PLANNING CONSULTATION RESPONSE

Application No	2026/0014
Proposal	Unit 2, Park Springs, Spring Hill Road, Grimethorpe, Barnsley S72 7BQ
Address	Proposed steel containers to be converted into a private bar with car sales offices above (Retrospective)
Date of Consultation Reply	3 rd June 2026
Consultee	Highways DC

SITE SURVEY
PARK SPRINGS
SPRINGHILL ROAD
GRIMETHORPE
S72 7BQ

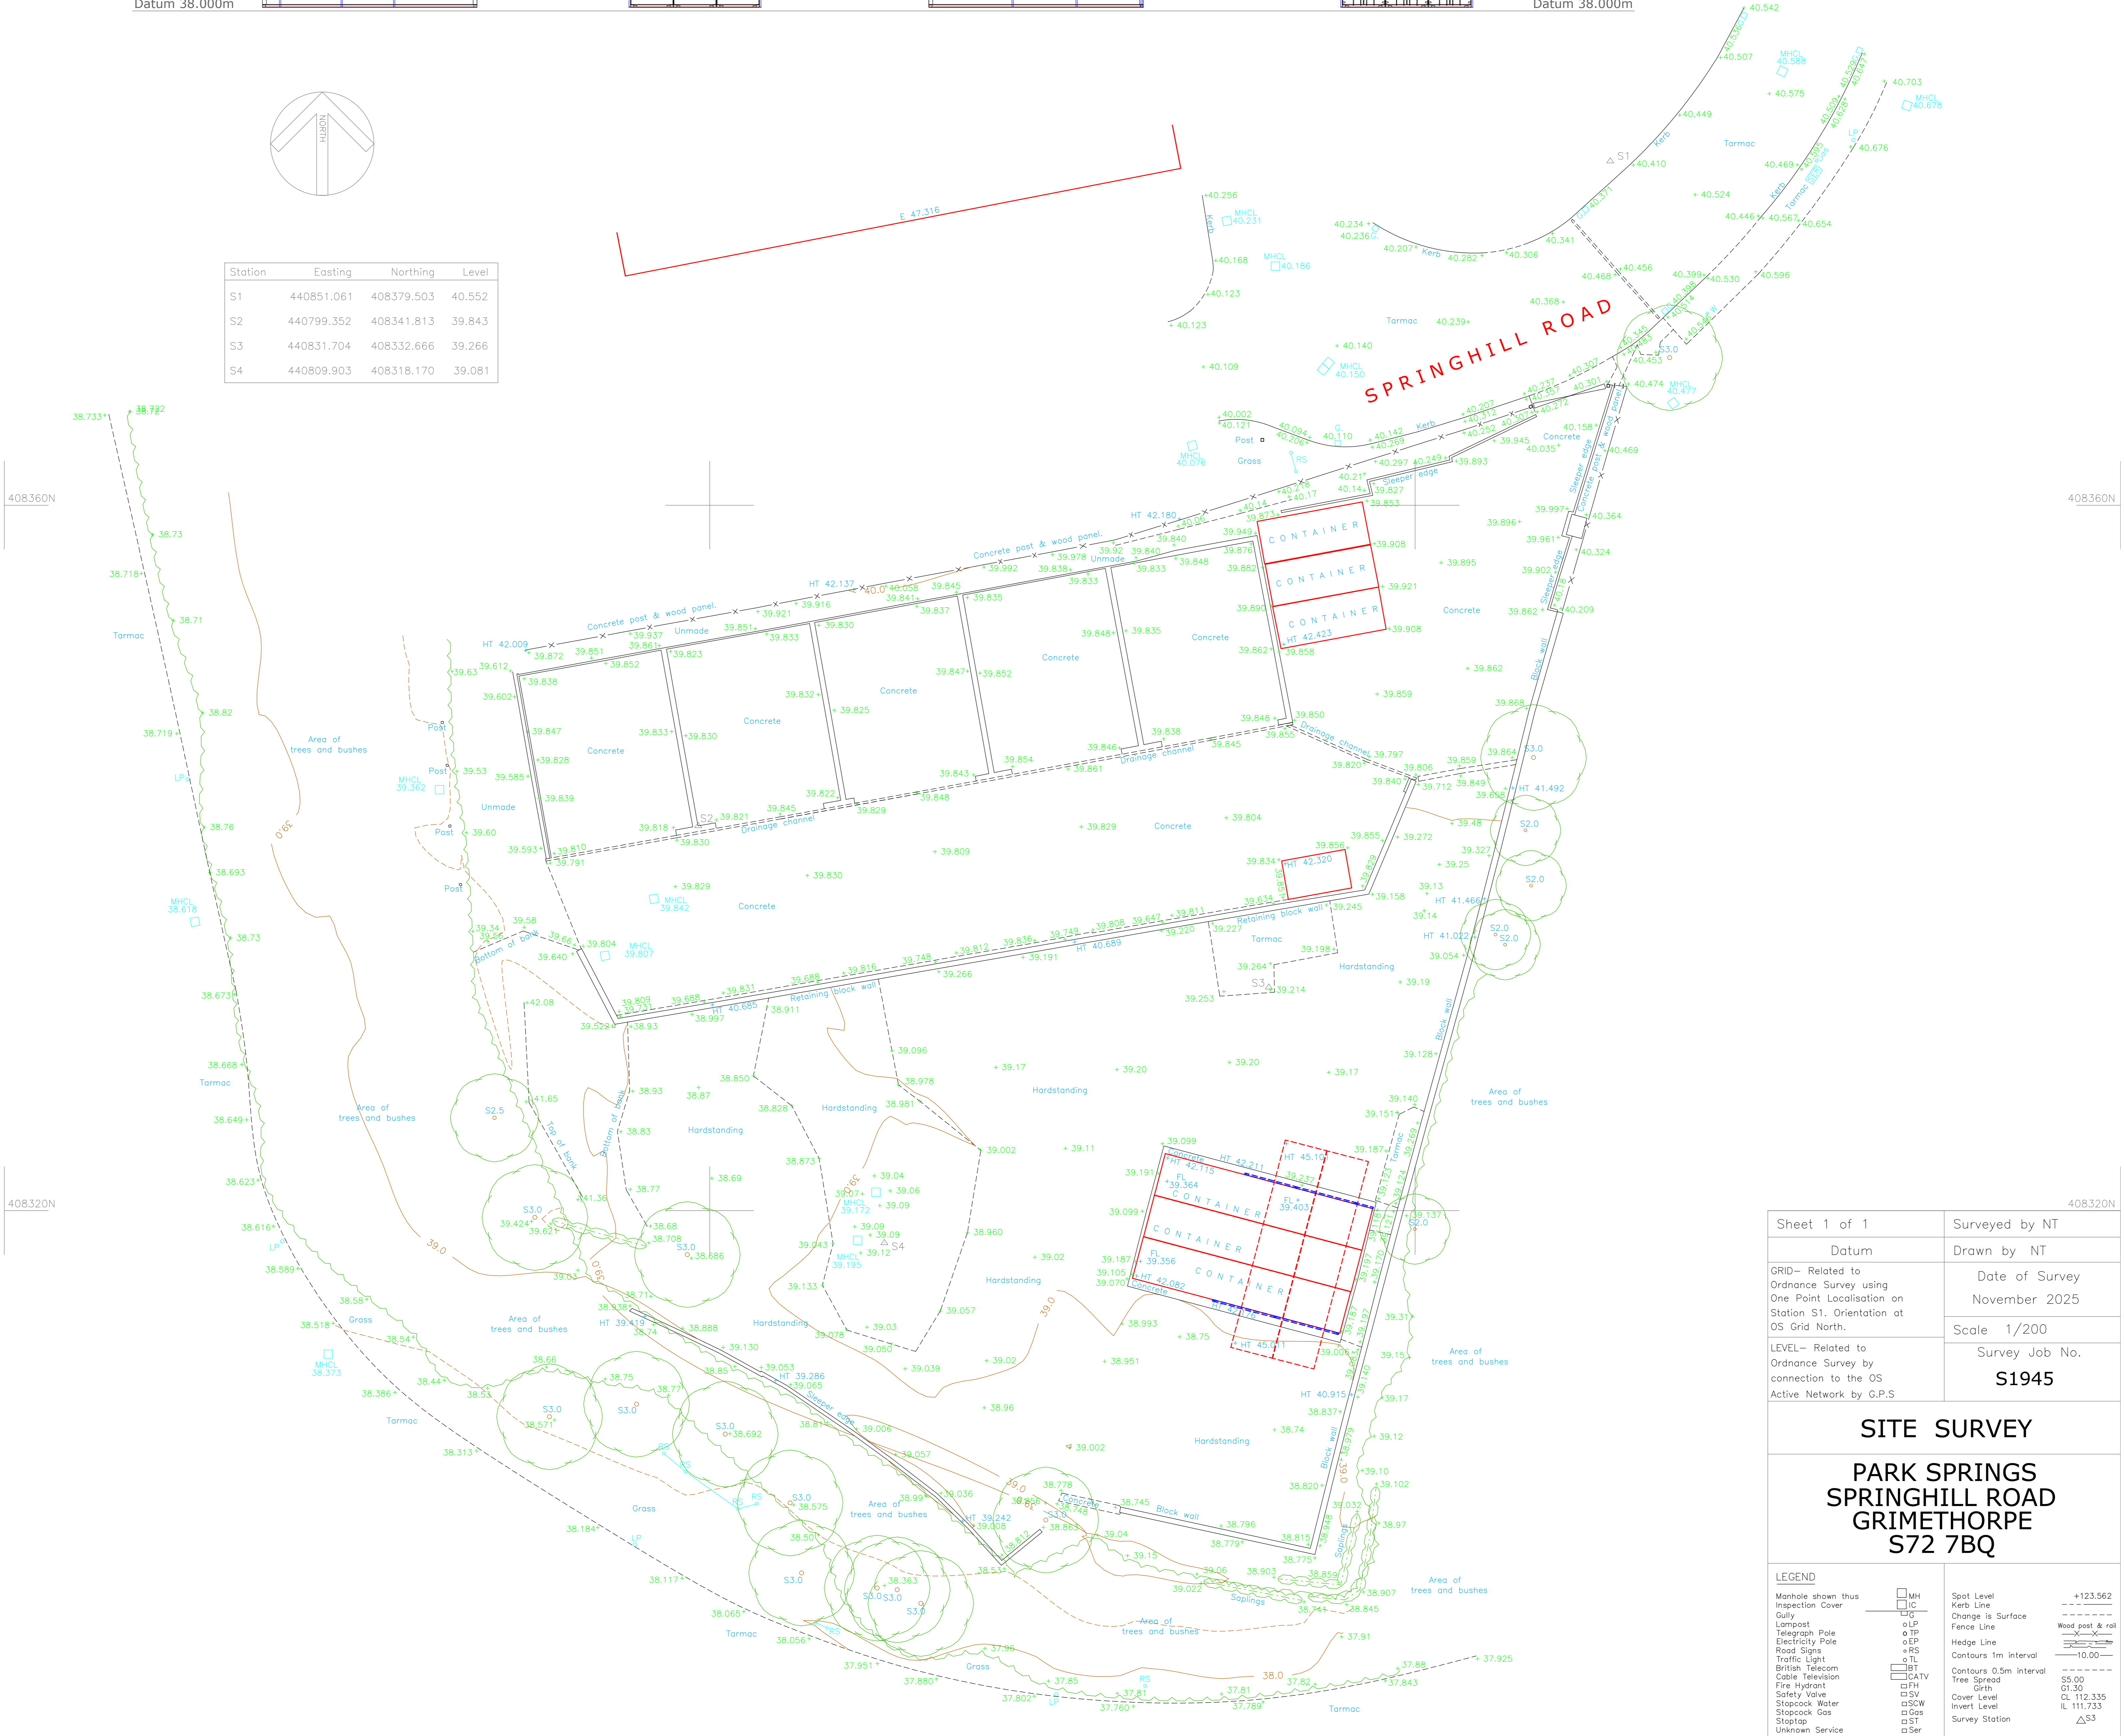
The submitted information includes a site plan with a hand drawn note which indicates the location of 10no. parking spaces, however, this does not correlate with the actual layout of the site. The submitted site survey plan does provide an accurate layout of the site, the location of all proposed parking spaces should therefore be accurately shown on this plan. It should be noted that each parking space should have minimum dimensions of 5m x 2.5m.
